Revision #5 narrative (Kitchen redesign)

DATE: May 31, 2023  
PROJECT ARCHITECT: ELEVEN18 ARCHITECTURE, PL  
CONTACT NAME AND NUMBER: Matt Conte, 407-745-5300

**PROJECT NAME:** The Springs of Ballentine  
**PERMIT NUMBER:** N/A  
**PROJECT NUMBER:**  
**FID NUMBER:**

PLEASE NOTE THE FOLLOWING REVISIONS TO THE PROPOSED SET OF DRAWINGS HAVE BEEN COMPLETED  
IN RESPONSE TO REVISED FOOD SERVICE DRAWINGS.

**A601**  
ENLARGED PLANS

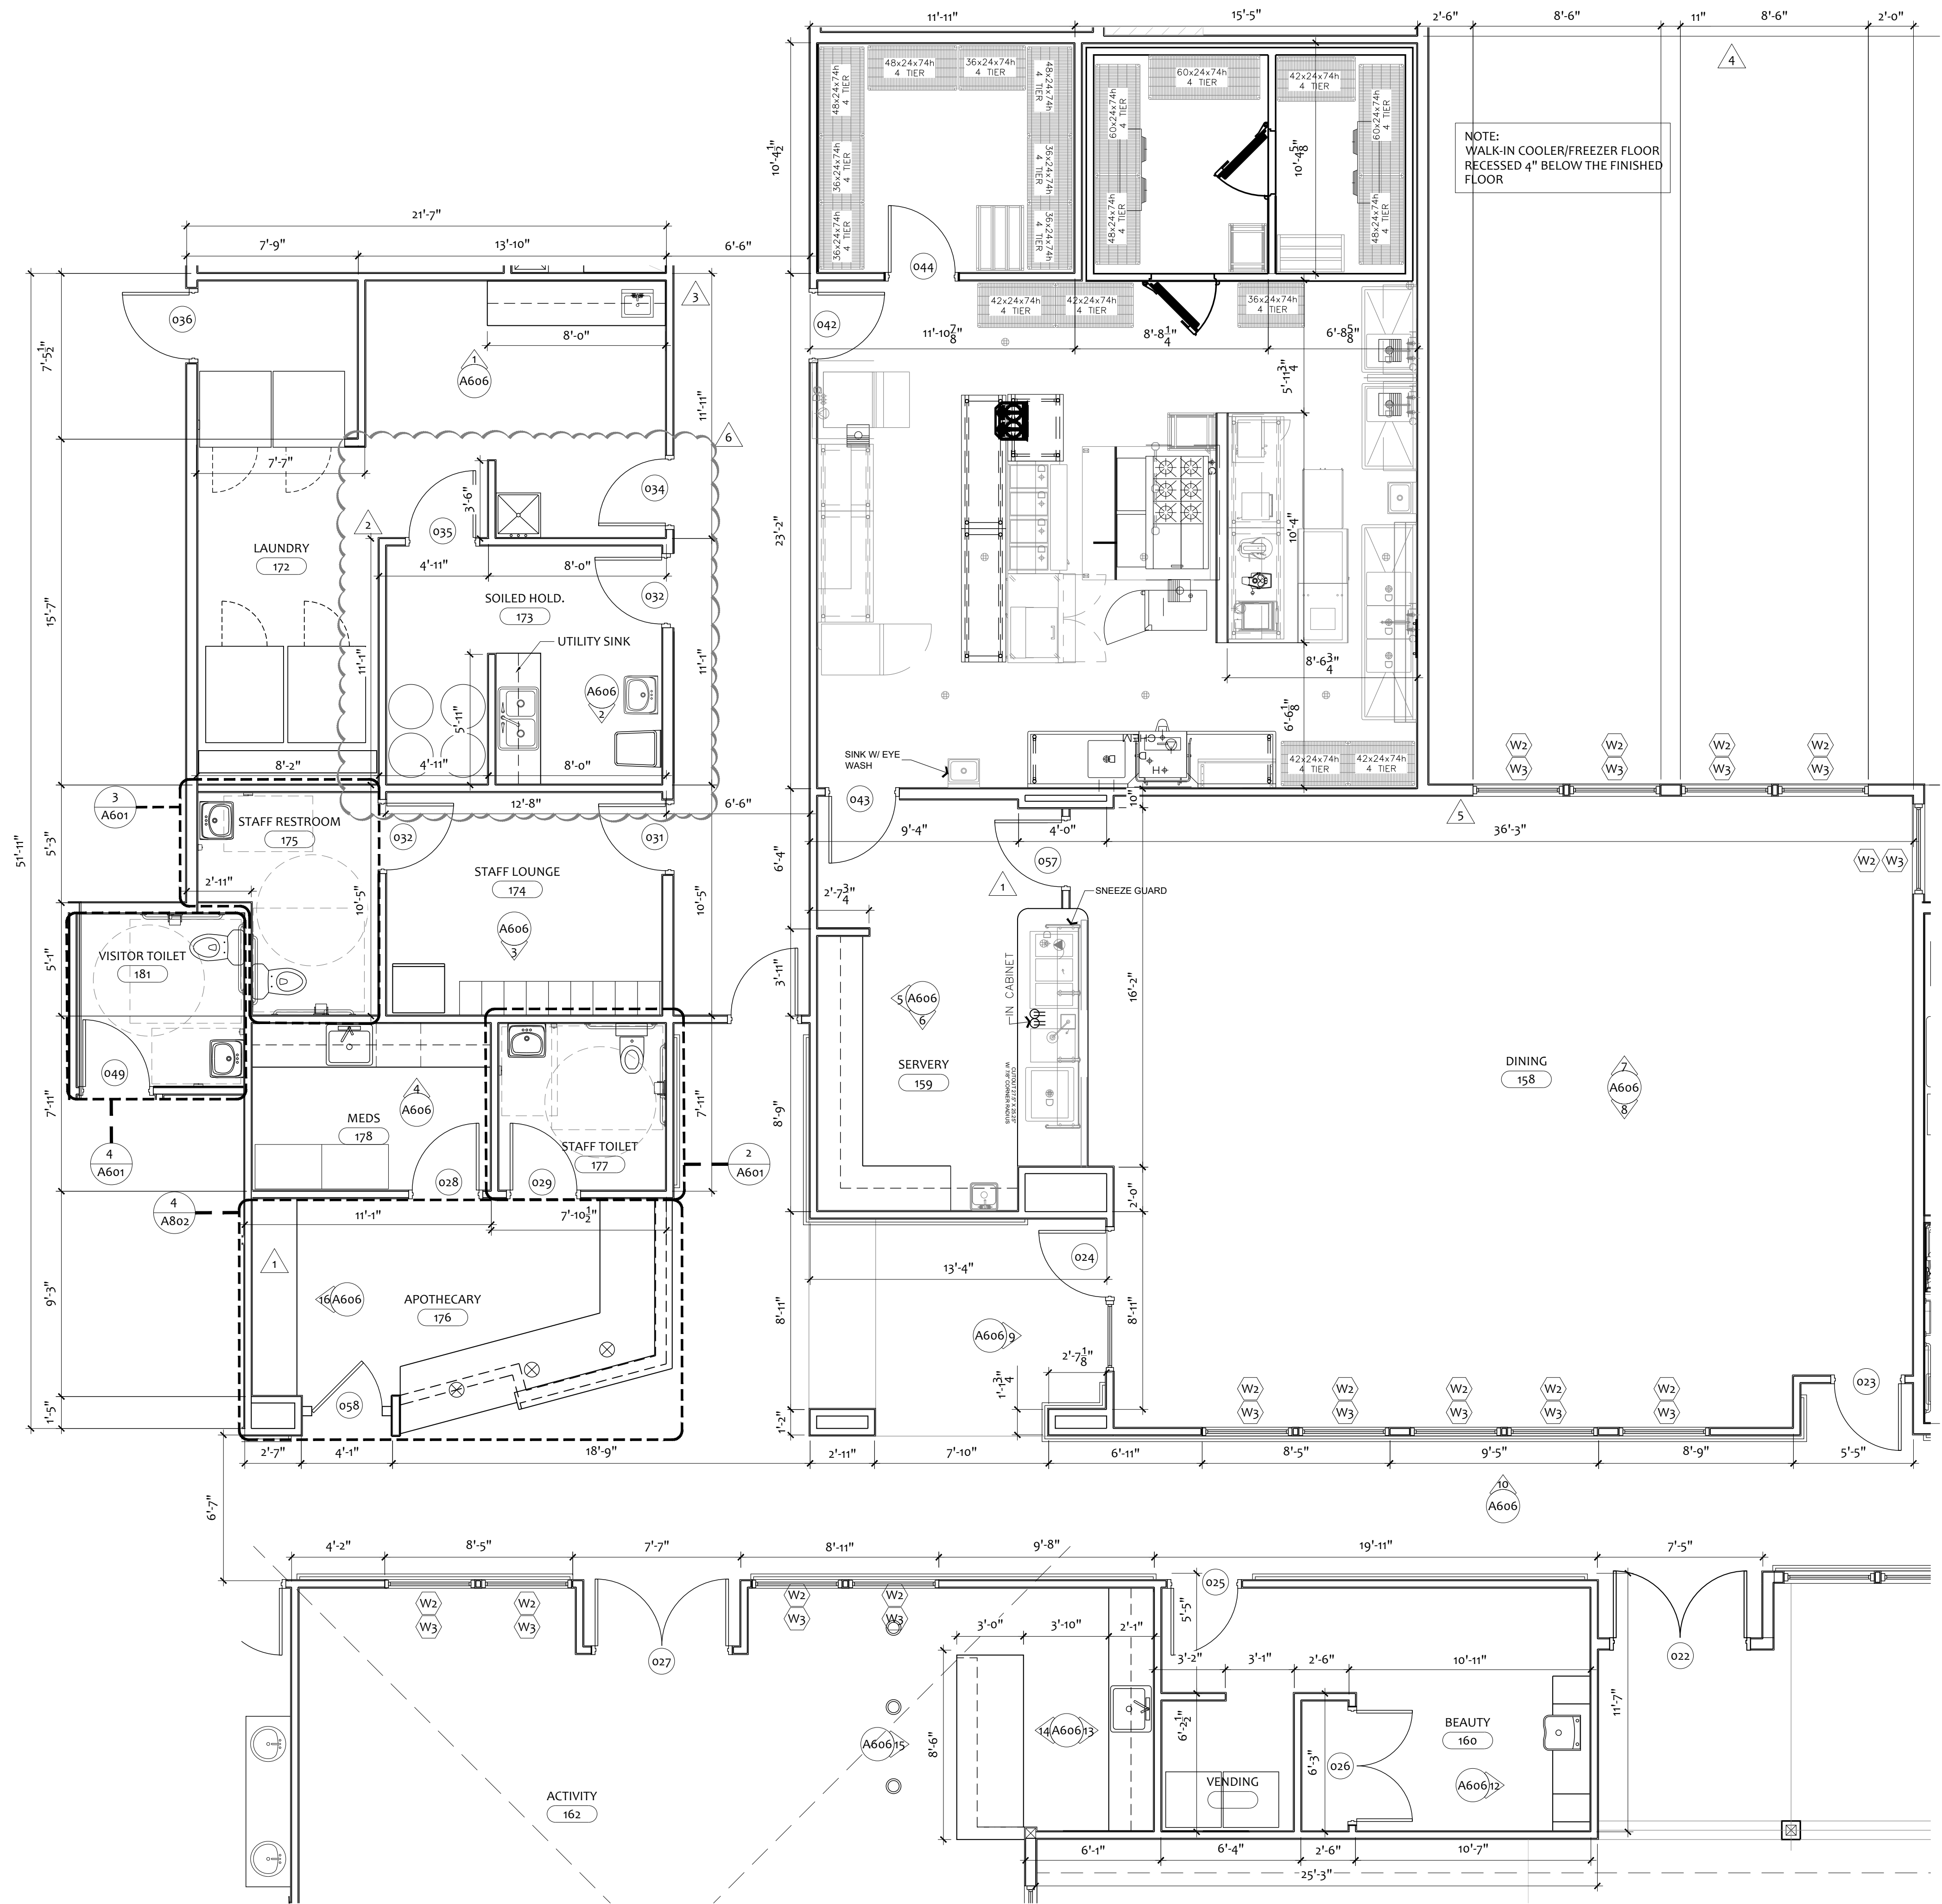
A601

Revised Kitchen layout in enlarged kitchen plan

**E203**  
 PARTIAL POWER PLAN

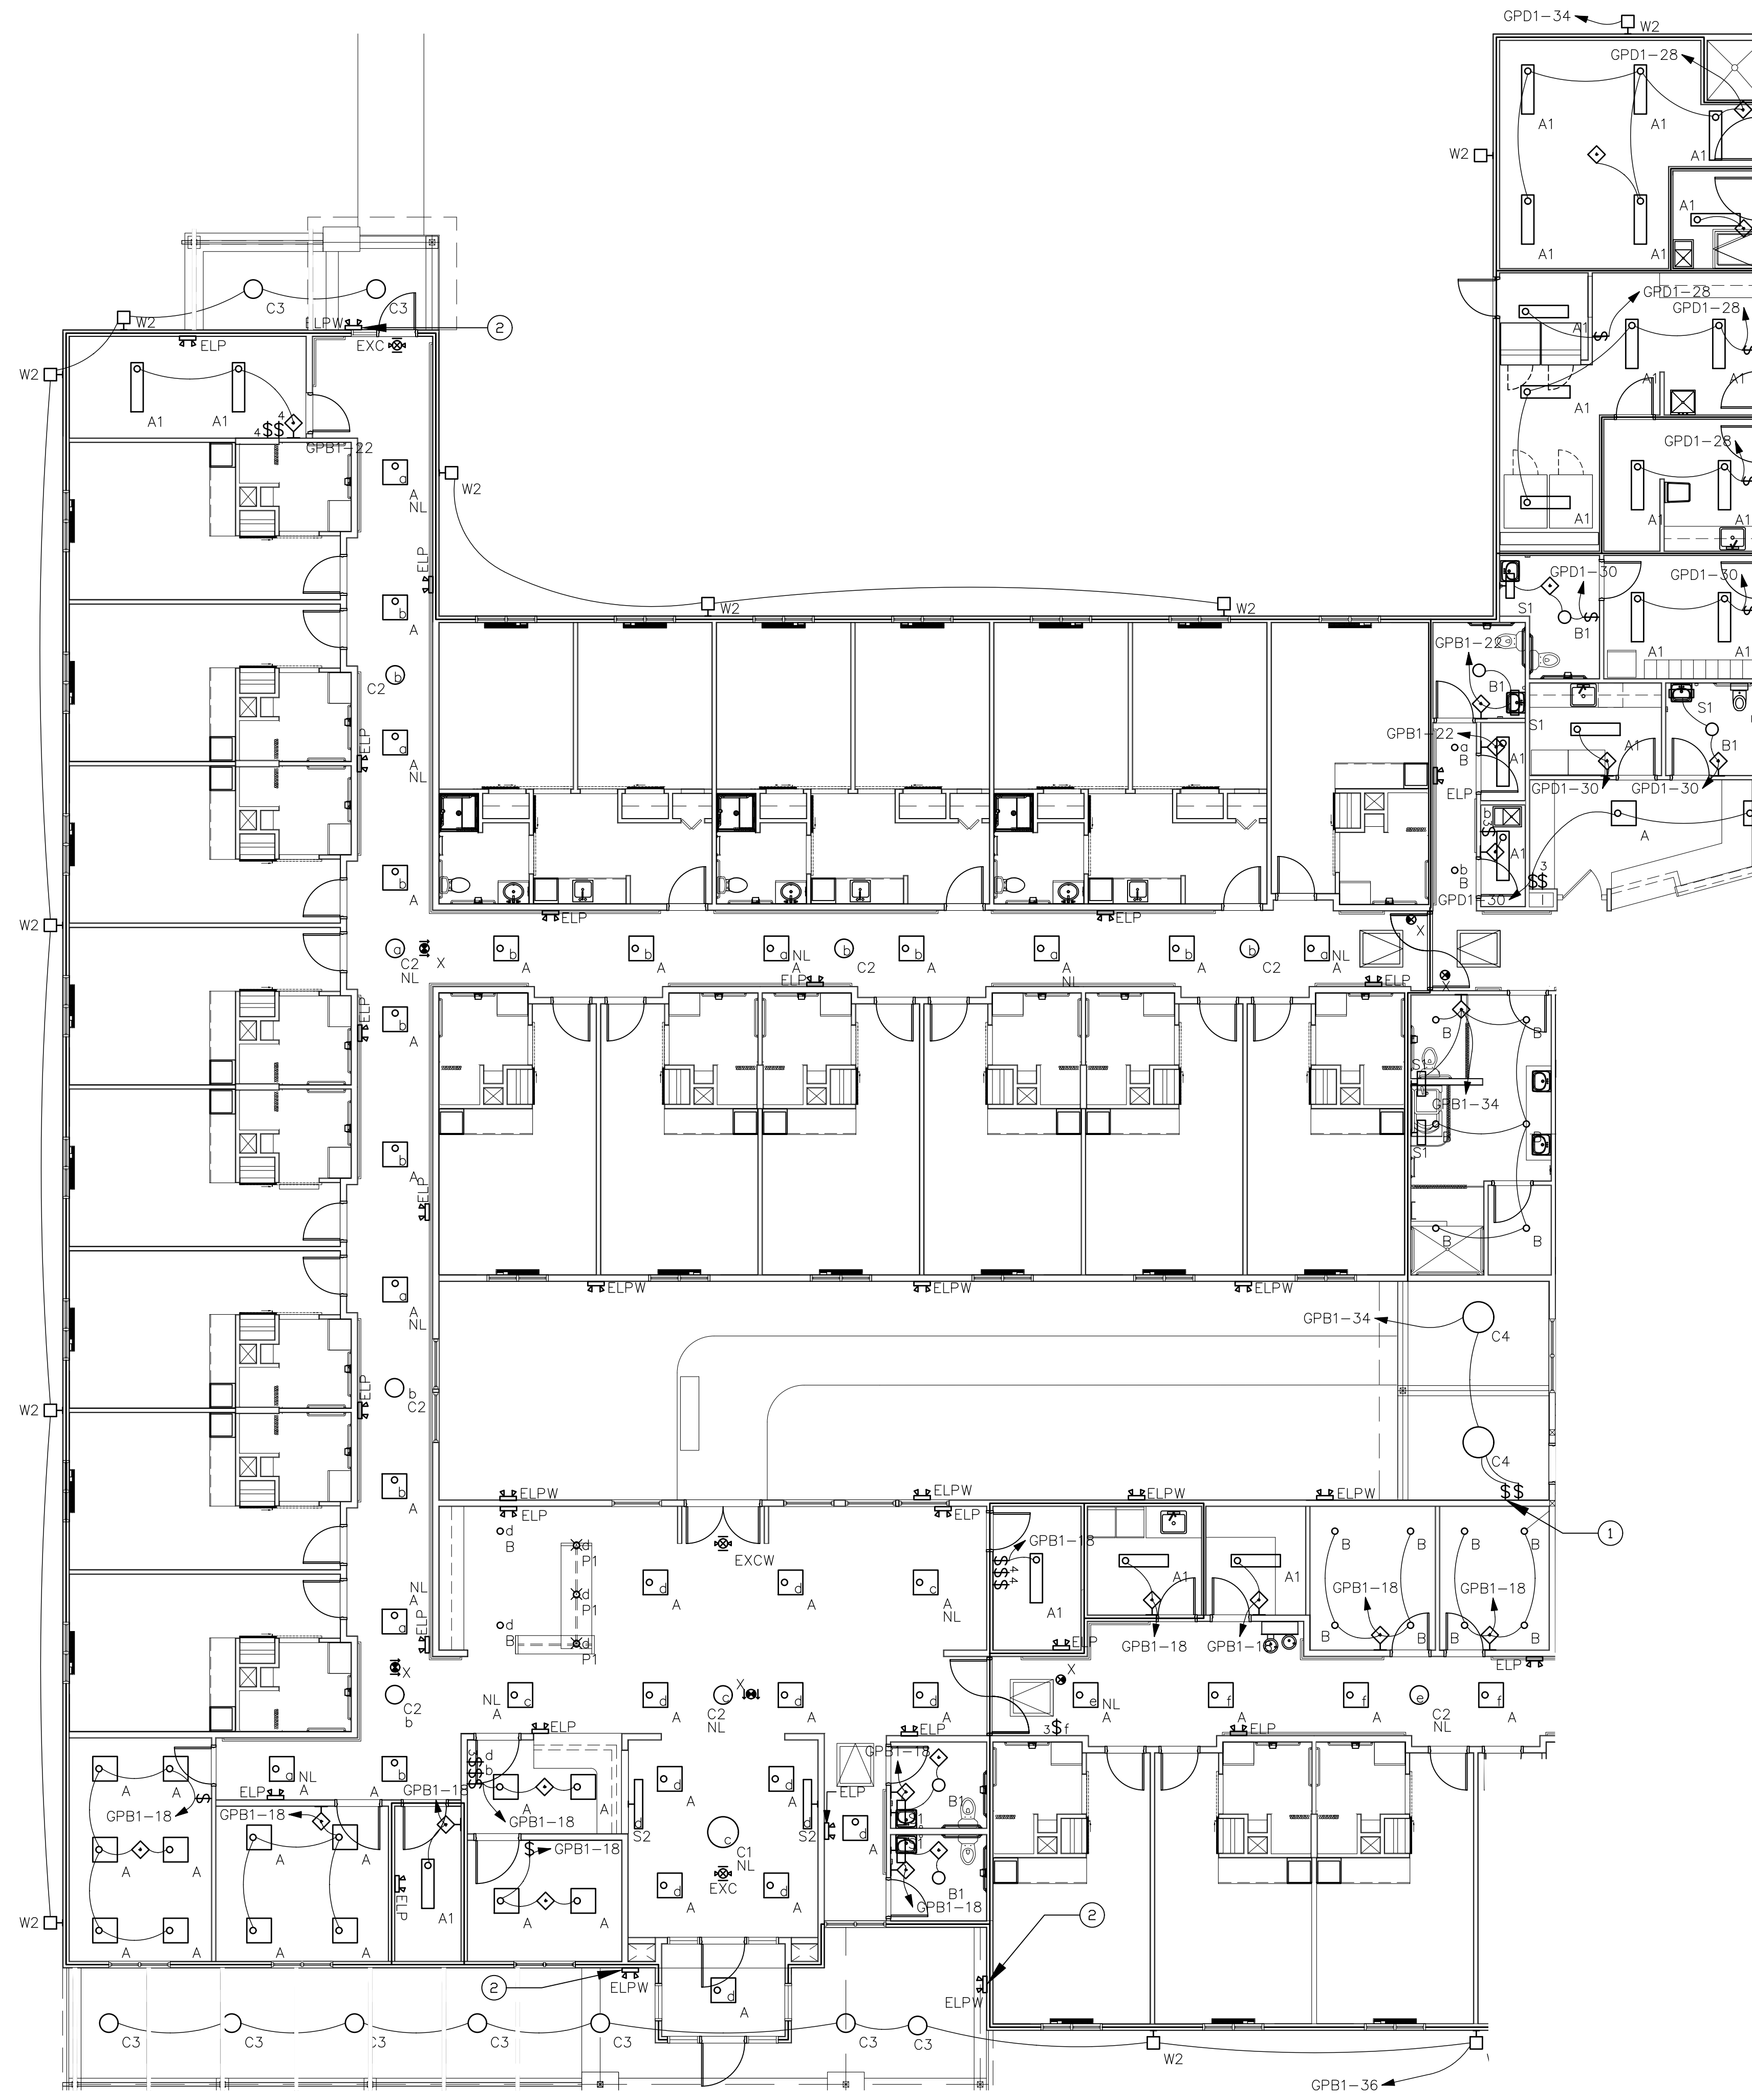
E203

Revised electrical power plan for kitchen

E205  
PARTIAL LIGHTING PLAN

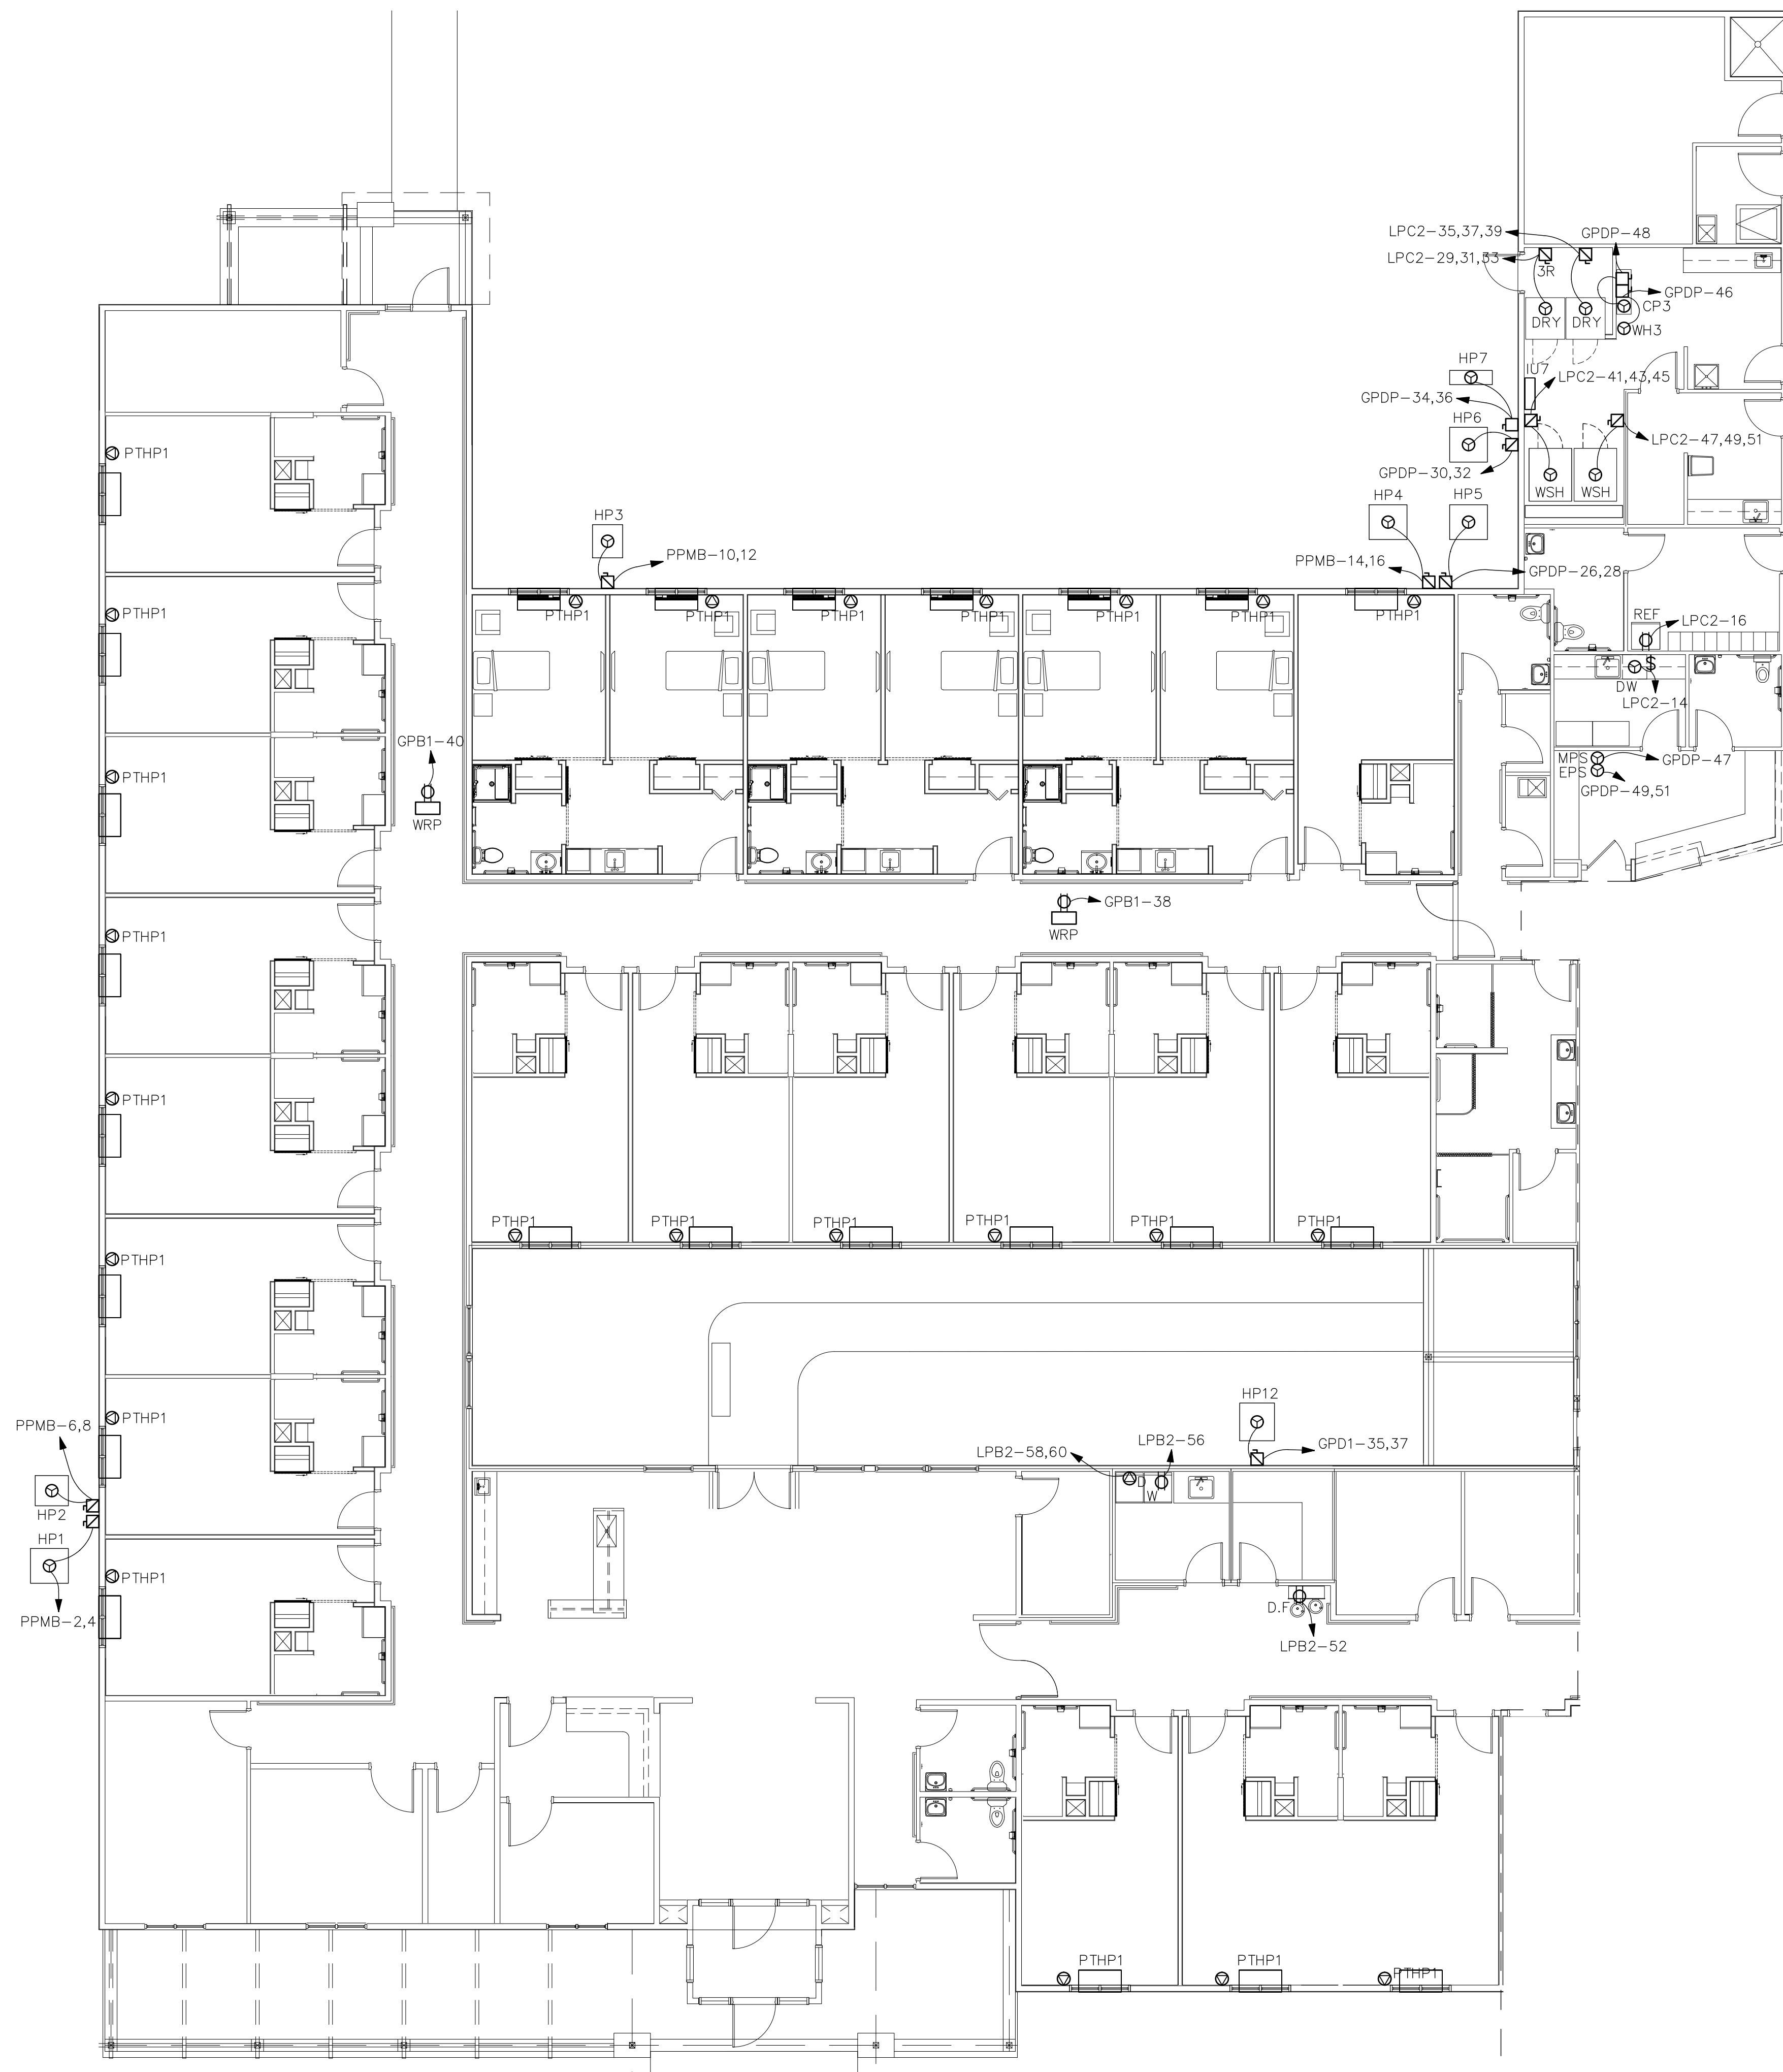
E205

Revised electrical lighting plan for kitchen
